Our ref: Yiribana Logistics Estate (SSD-10272349)

Subject: Yiribana Logistics Estate – Request for Additional Information

STORMWATER DRAINAGE MASTER PLAN
SCALE 1:1000

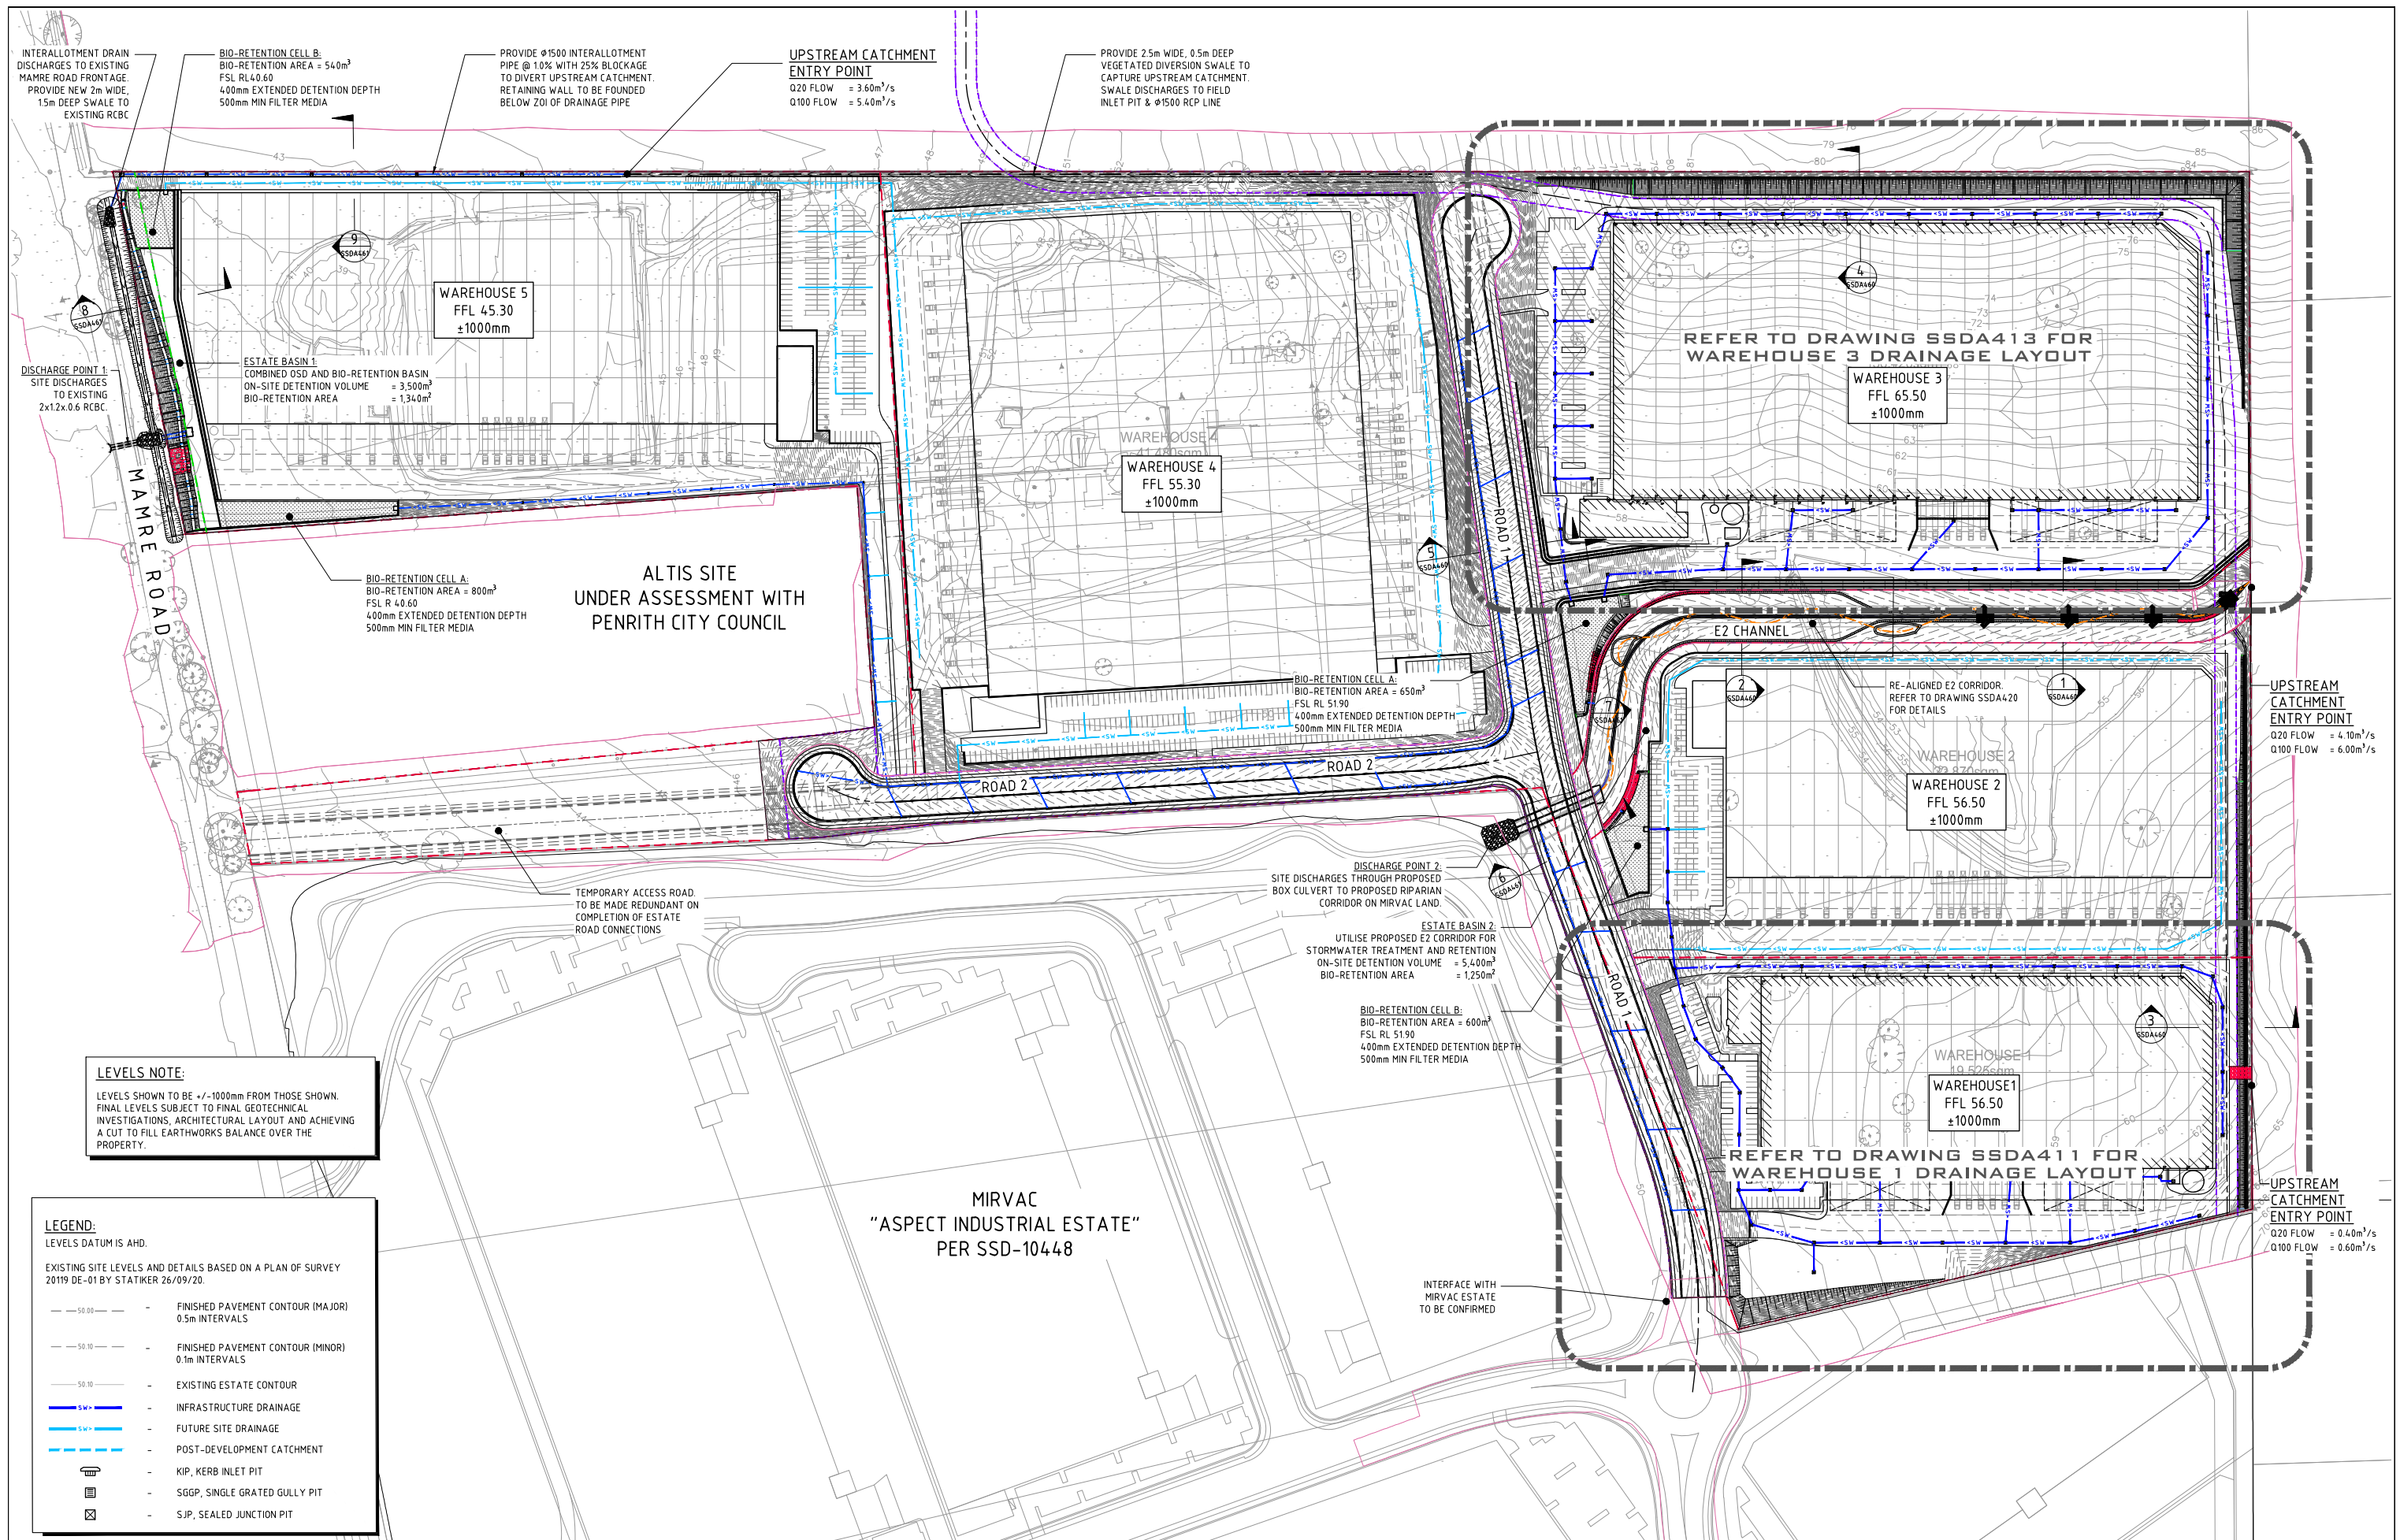
- It appears the civil drawings package (Appendix H of the Response to Submissions) still contains drawings of the fully developed estate proposed under the concept DA. As you are proposing to withdraw the concept DA, please ensure the civil drawings reflect the amended development application. In this case, the civil drawings of the broader estate should not show Warehouses 2, 4 and 5.

E2 CORRIDOR ALIGNMENT PLAN
SCALE 1:500

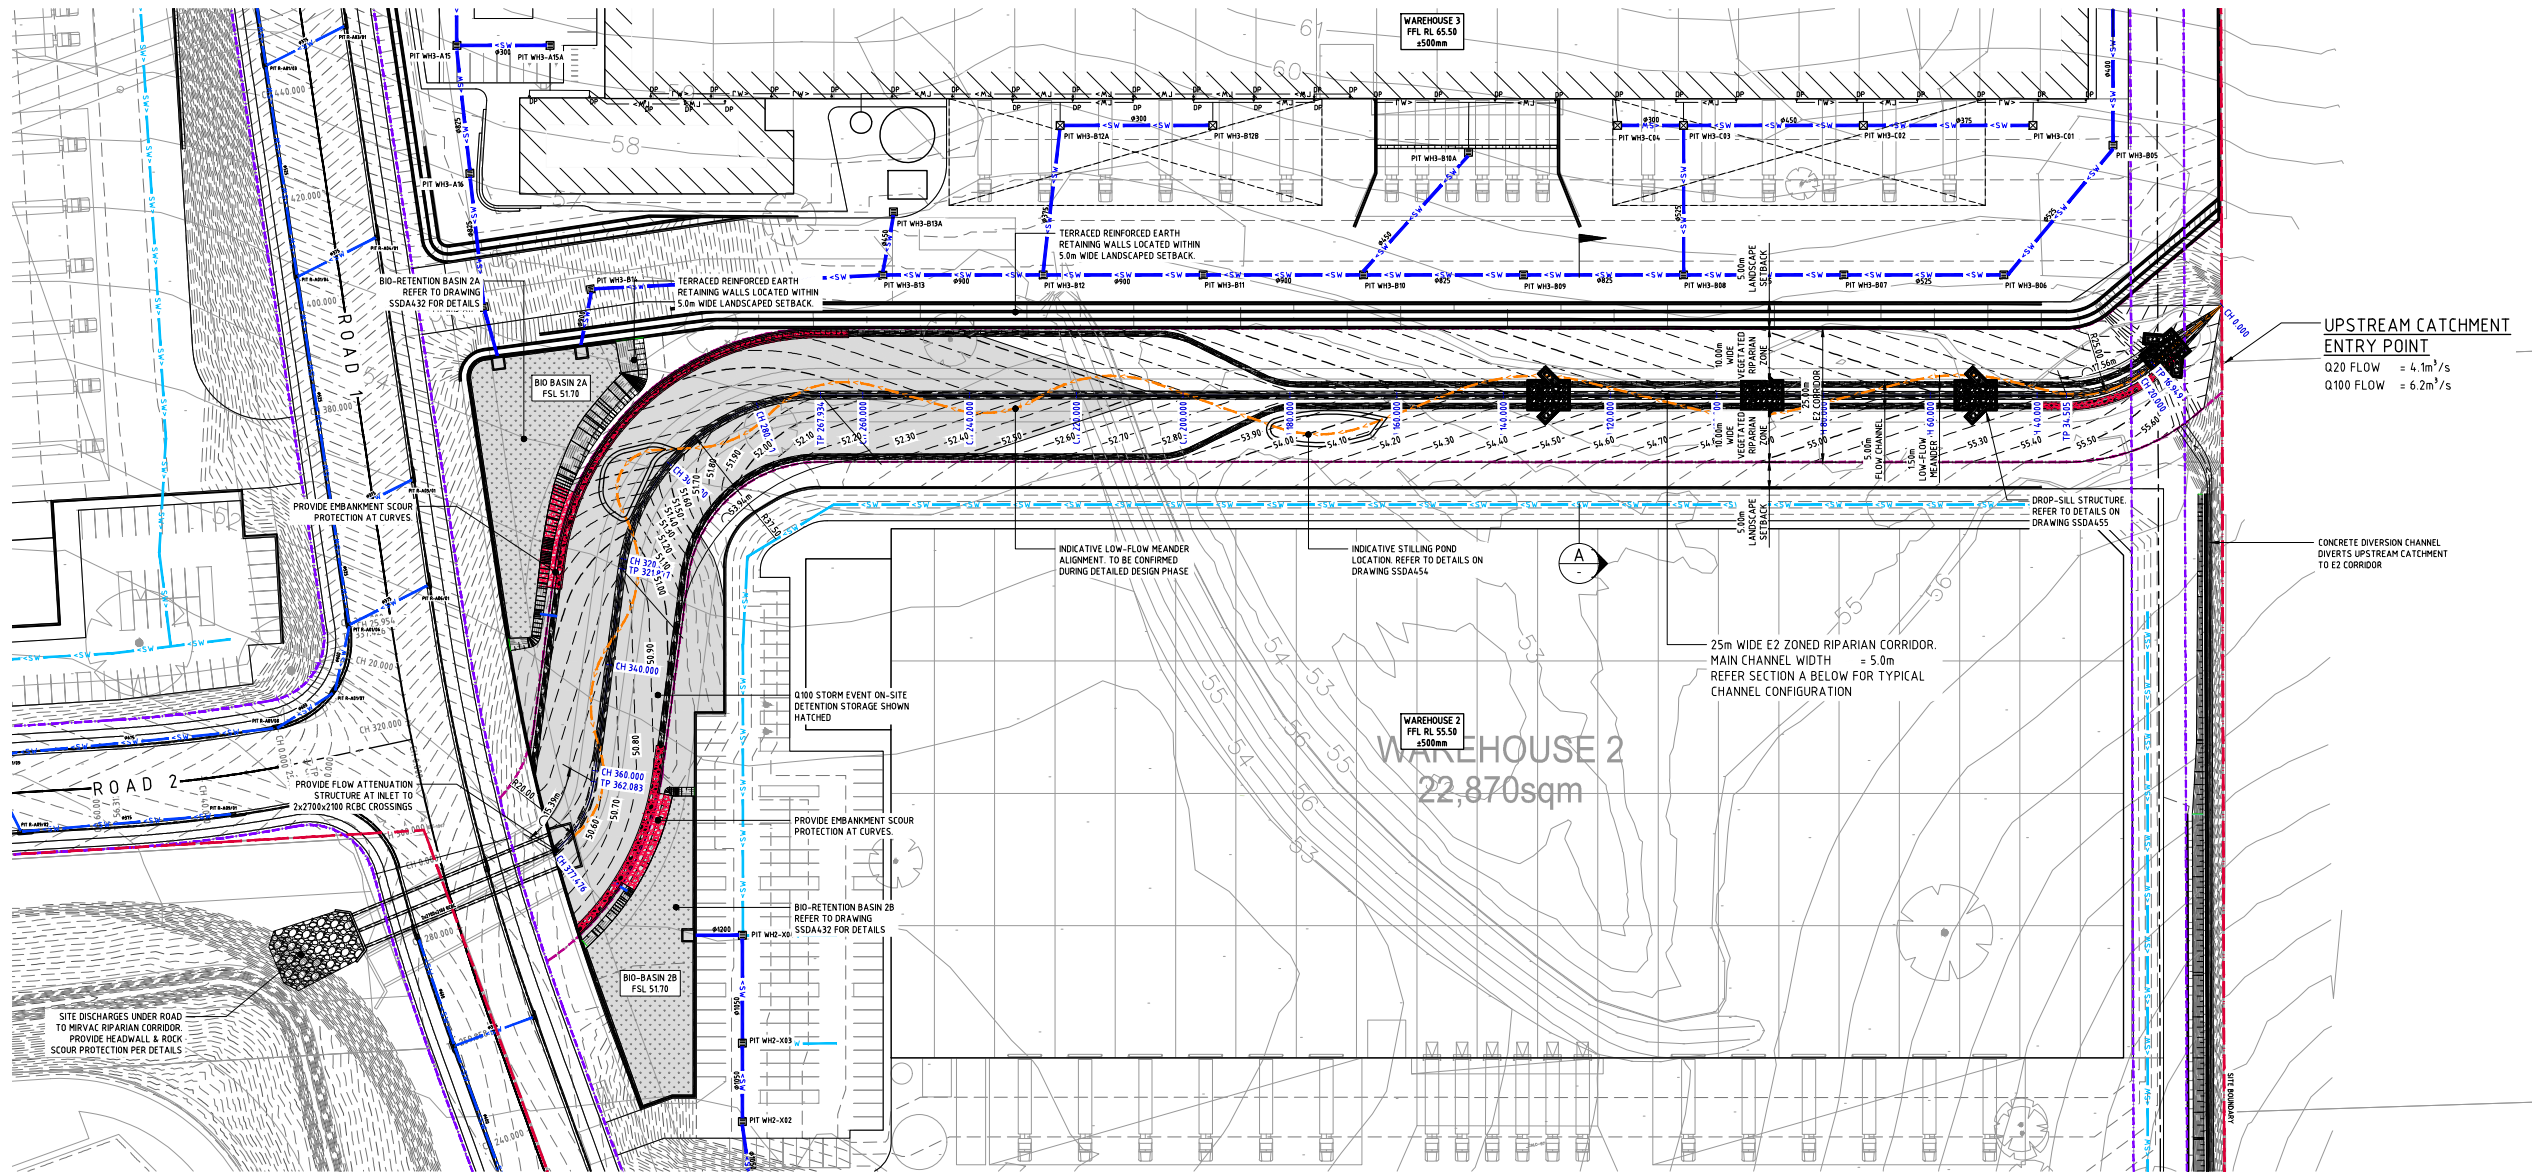
- Please ensure the civil, landscaping and architectural drawings show the proposed freight corridor alignment within the site.
- Demonstrate that access to the proposed automated vehicle network (freight corridor) can be achieved from the site.
